Ballygrehan,
Templeboy,
Co Sligo.
F91 PD62

An Coimisiún Pleanála,
64 Marlborough Street,
Dublin 1

RE: Planning Application for Proposed Wind Farm Development SSE Crumhach Wind Farm, Co. Sligo. An Coimisiún Pleanála - Case reference: PAX21.324561. Expression of concerns/issues arising - Mary T Finnegan concerning lands at Leharrow, Dromore West Co Sligo. Folio - SL 10702 refers.

Annex 1- Turn location 17

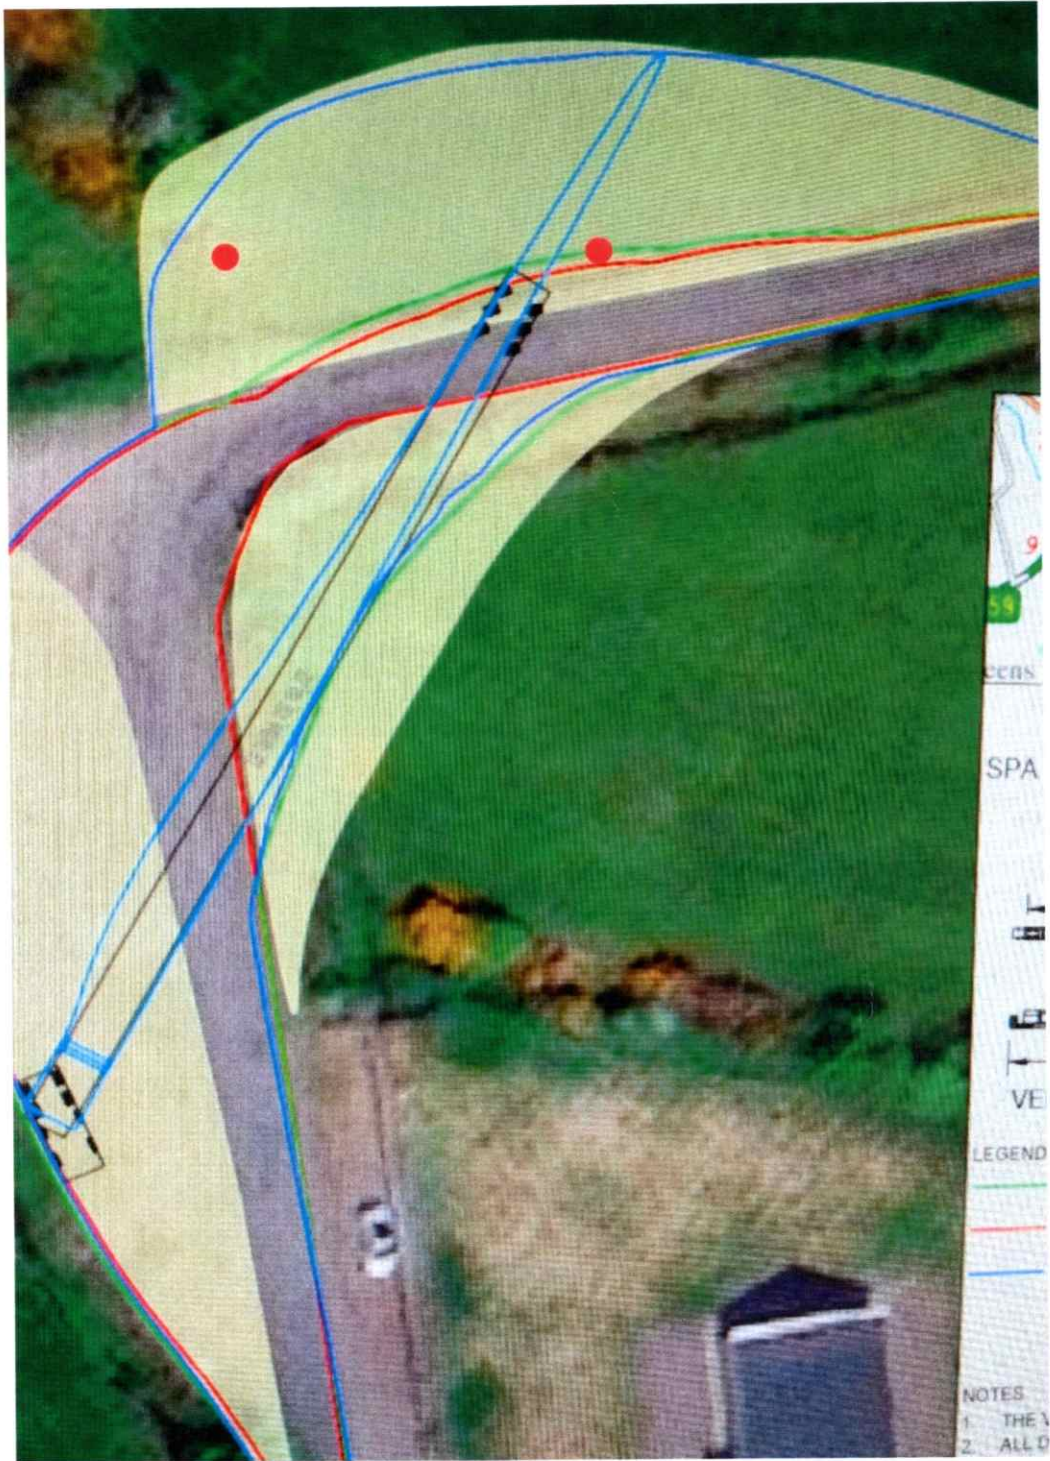
Crucially, the lands are adjacent to the 90 degree narrow bend on L63072 at Lehaarrow, Dromore West. Map b – Appendix 1 outlines. This is referred to as Location 17 in the submission document Map c – Appendix 1 refers. My concerns and the issues, I request to be addressed forthwith are as follows:-

(i) It is acknowledged by the parties involved in the construction and transportation of these numerous abnormally large loads (120 loads – application) that the physical turning radius required for an articulated abnormal load vehicle of this size (74m rotor blades and 77.8m vehicle- application) can not be safely achieved within the public road boundary alone. Any attempt to navigate this corner will inevitably result in mechanical over-sail and encroachment on my private property – Location 17 map. More importantly, it is likely to

(iii) Travelling along this route on a daily, I note a lot of power lines at Location 17 and again, it is my opinion that some of these will have to be moved to facilitate the transportation of these numerous abnormally heavy loads. Has there been any consultation with the property owners in the vicinity in this regard? It is likely that there will be serious disruption to power in the area for a period, perhaps, extended. I don't see anything in the application online referring or dealing with this issue. Can this issue be clarified, please?
